**KIRKLEES METROPOLITAN COUNCIL  
INVESTMENT & REGENERATION SERVICE**

**DELEGATED DECISION TO DETERMINE PLANNING APPLICATIONS**

| Reference No:         | <b>2025/62/93554/W</b>                            |
| Site Address:         | 5, Tom Lane, Crosland Moor, Huddersfield, HD4 5PU |

CLIENT	Mr Ishtiaq		
ADDRESS	5 Tom Lane, HD4 5PU Crossland moor, Huddersfield		
PROJECT	Two Storey Rear Extension		
DRAWING	Proposed Layout and Elevation		
DRAWN	UH	DATE	JUN 25
		SCALE	1.50@A1
DWG No.	1528/03		
STATUS	PLANNING

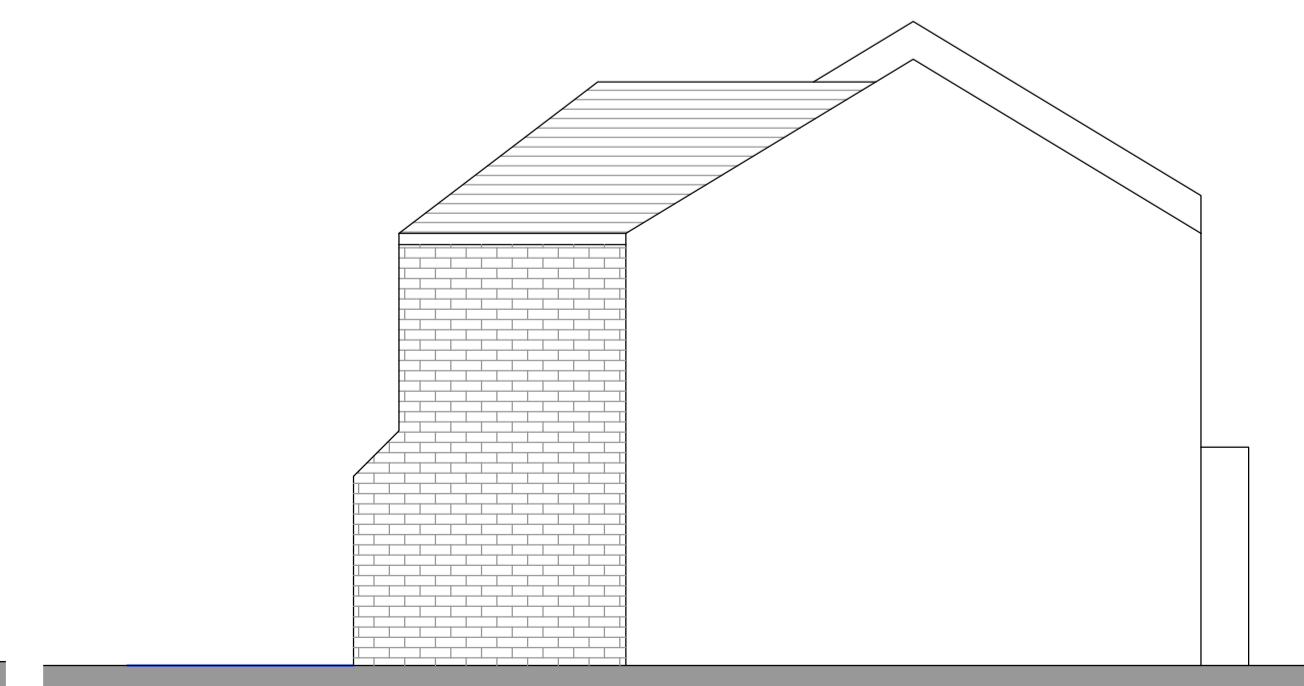
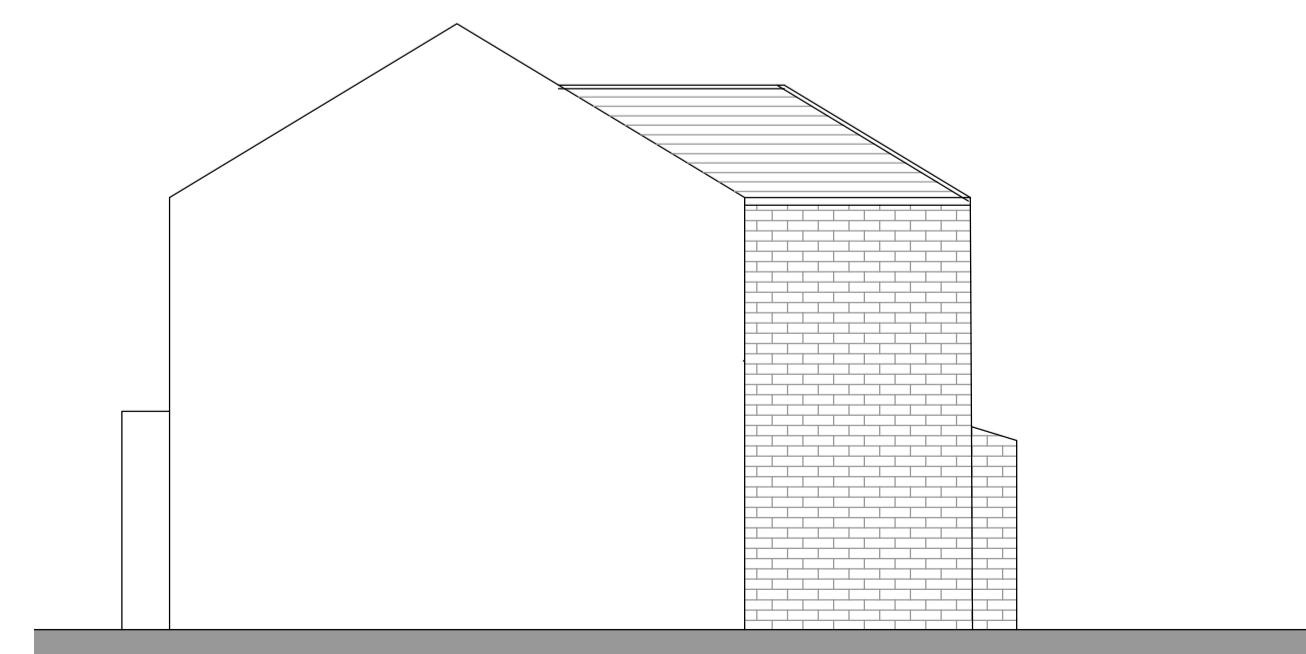
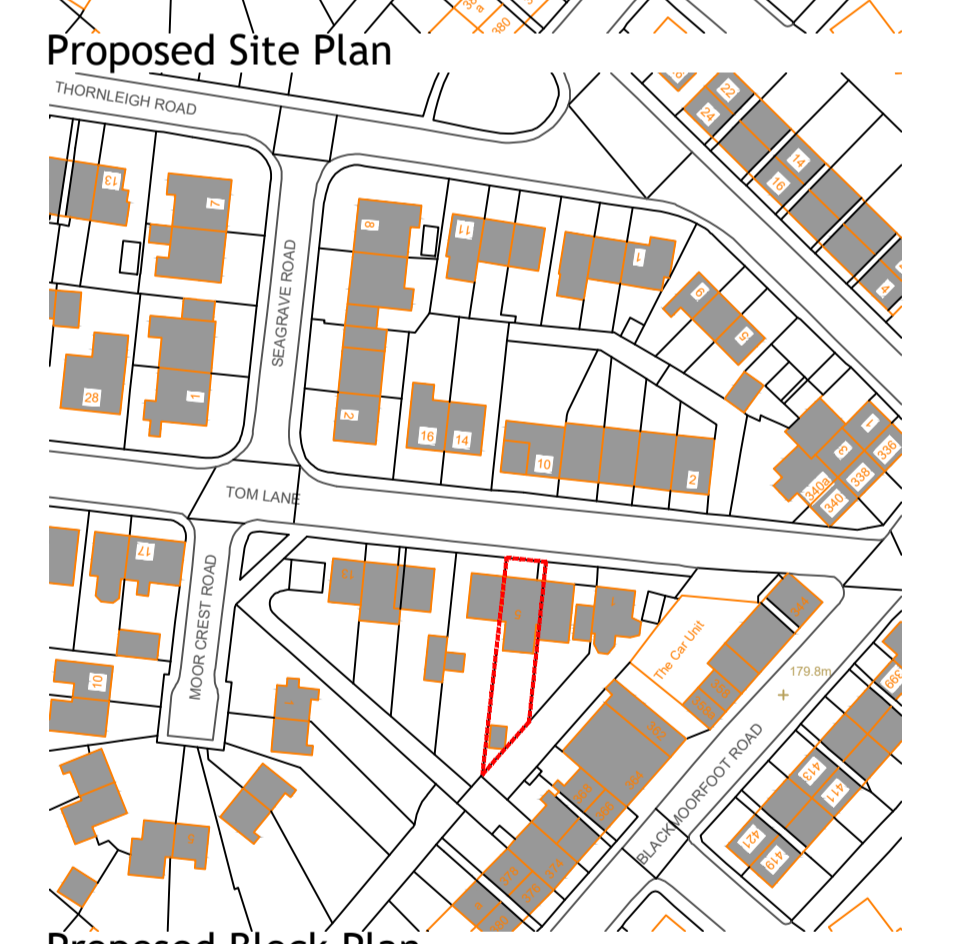
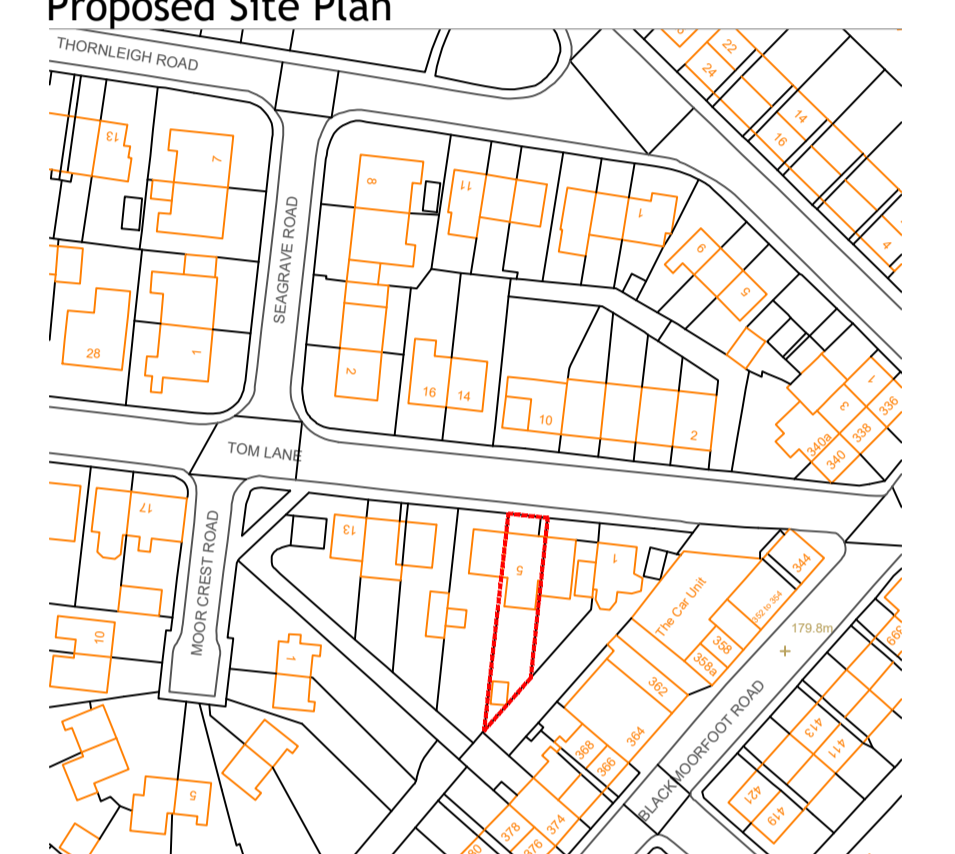
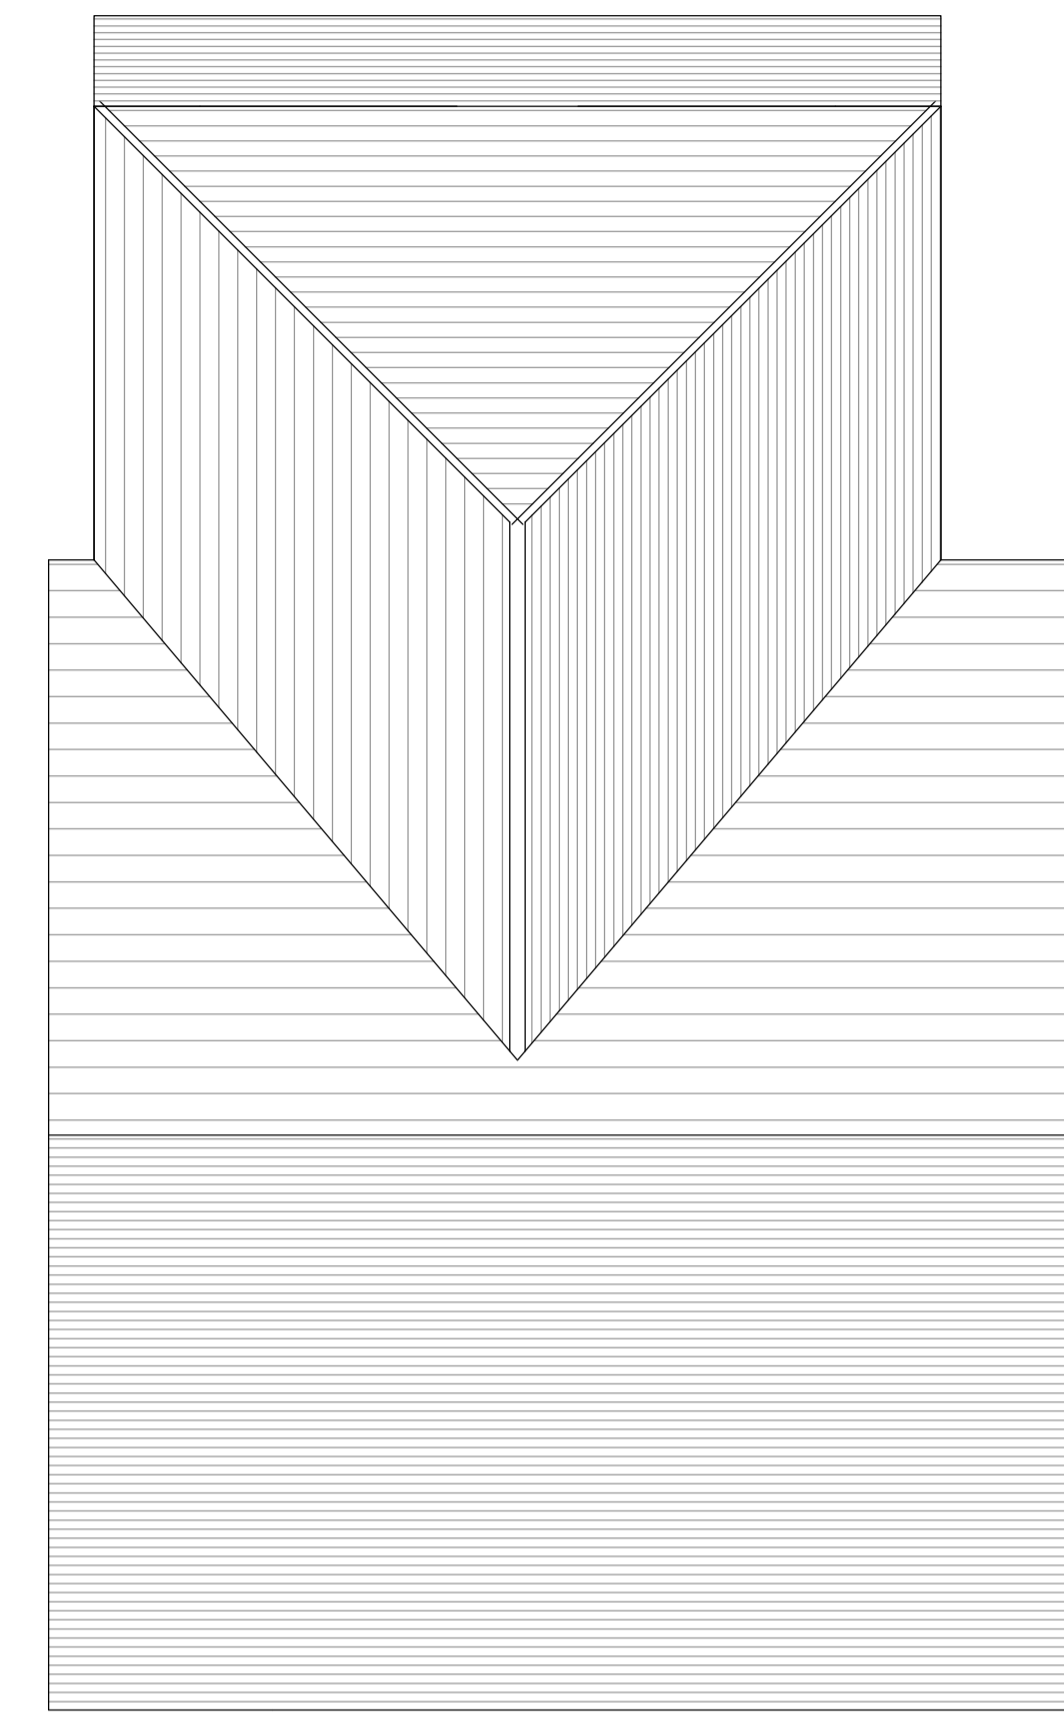
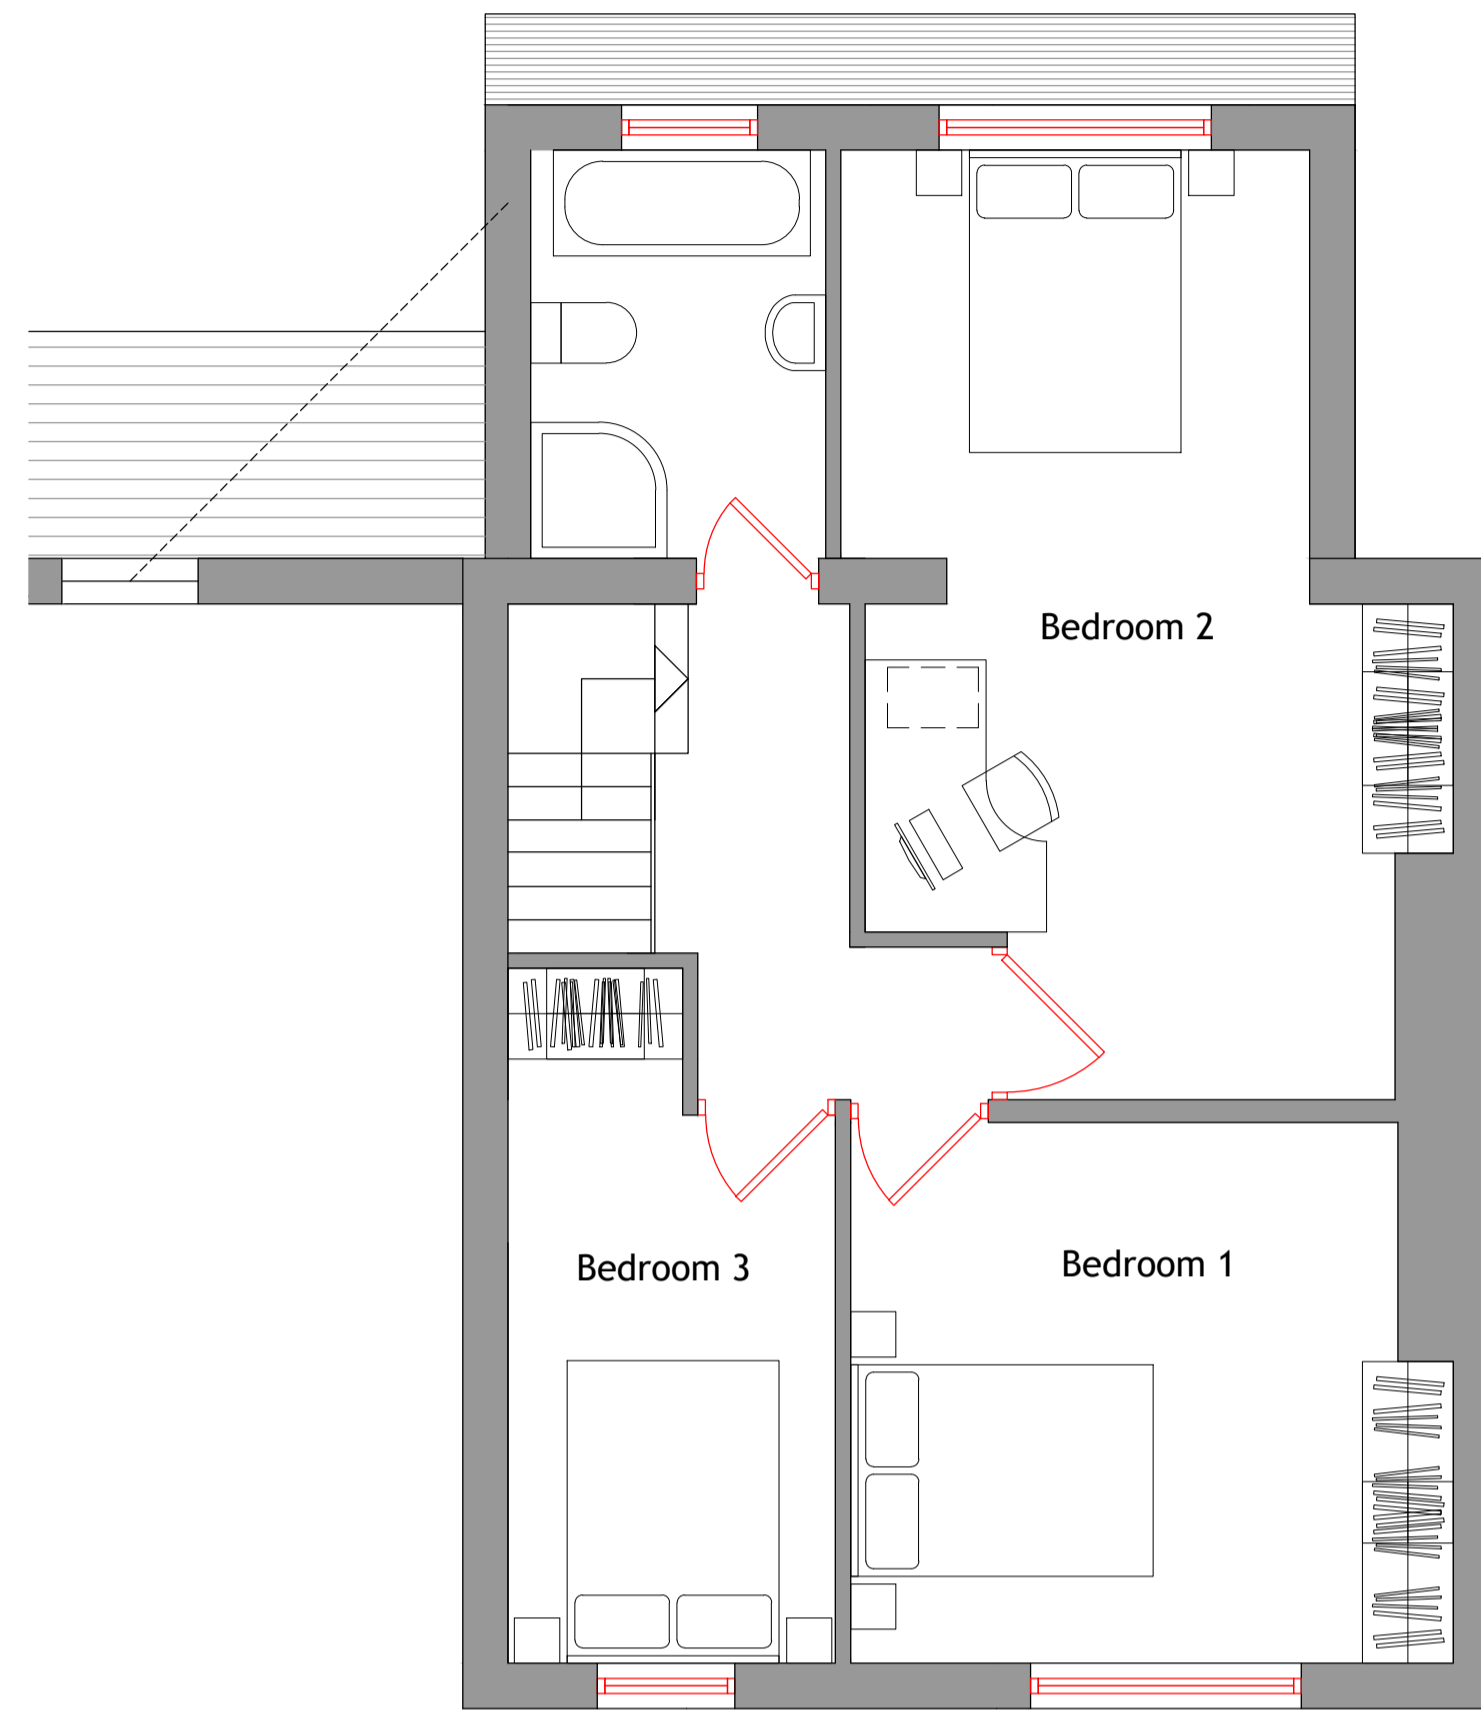
In relation to the neighbouring property to the east, No. 3, the proposal would result in a loss of late afternoon and evening sunlight. The applicant’s agent has confirmed the first floor window closest to the proposed extension serves a bathroom, therefore the proposal is not considered to lead to a harmful loss of light to the habitable windows. The submitted floor plans illustrate the ground floor projection would achieve a 45 degree line taken from the corner of the extension.

However, in terms of overbearing/oppressive impacts, owing to the site levels, No. 5 sits at a slightly higher level, and its existing rear extension is already elevated, with steps providing access down to the garden. Although No. 3 benefits from a small single-storey rear extension, it also has a relatively limited rear garden area. Given the difference in levels and the cumulative height and projection of the existing and proposed extensions, the development would appear overbearing and oppressive when viewed from No. 3. This relationship would result in a detrimental impact on the residential amenity of the occupiers, particularly having regard to their modest private amenity space.

A previous permission was granted for a two-storey rear extension at the site (ref: 2021/92389). Under that scheme, the element closest to the shared boundary projected only 1 m at first-floor level, with the 3 m first-floor projection positioned approximately 2.6 m away from the boundary. This separation was considered acceptable as it reduced the impact on neighbouring amenity. However, the first-floor extension now proposed under application 2025/93554 would be positioned significantly closer to the common boundary and would introduce a materially greater sense of enclosure. Officers consider that this would result in an oppressive and overbearing impact on the occupants of No. 3.

In conclusion, taking the above into account, it is considered that the proposal would result in an unacceptable impact on the residential amenity of the occupants of No. 3. The development is therefore contrary to Policy LP24(b) of the Kirklees Local Plan, Principle 6 of the adopted House Extensions and Alterations SPD, and the guidance set out in Chapter 12 of the National Planning Policy Framework.

1. The proposed development, by reason of its siting, scale and proximity to neighbouring property would result in an overbearing and oppressive impact upon the residential amenity of the occupiers of the adjoining dwelling No 3 Tom Lane. To permit such a development would be contrary to Policy LP24(b) of the Kirklees Local Plan, Key Design Principle 6 of the adopted House Extensions and Alterations SPD, and policies within Chapter 12 of the National Planning Policy Framework.
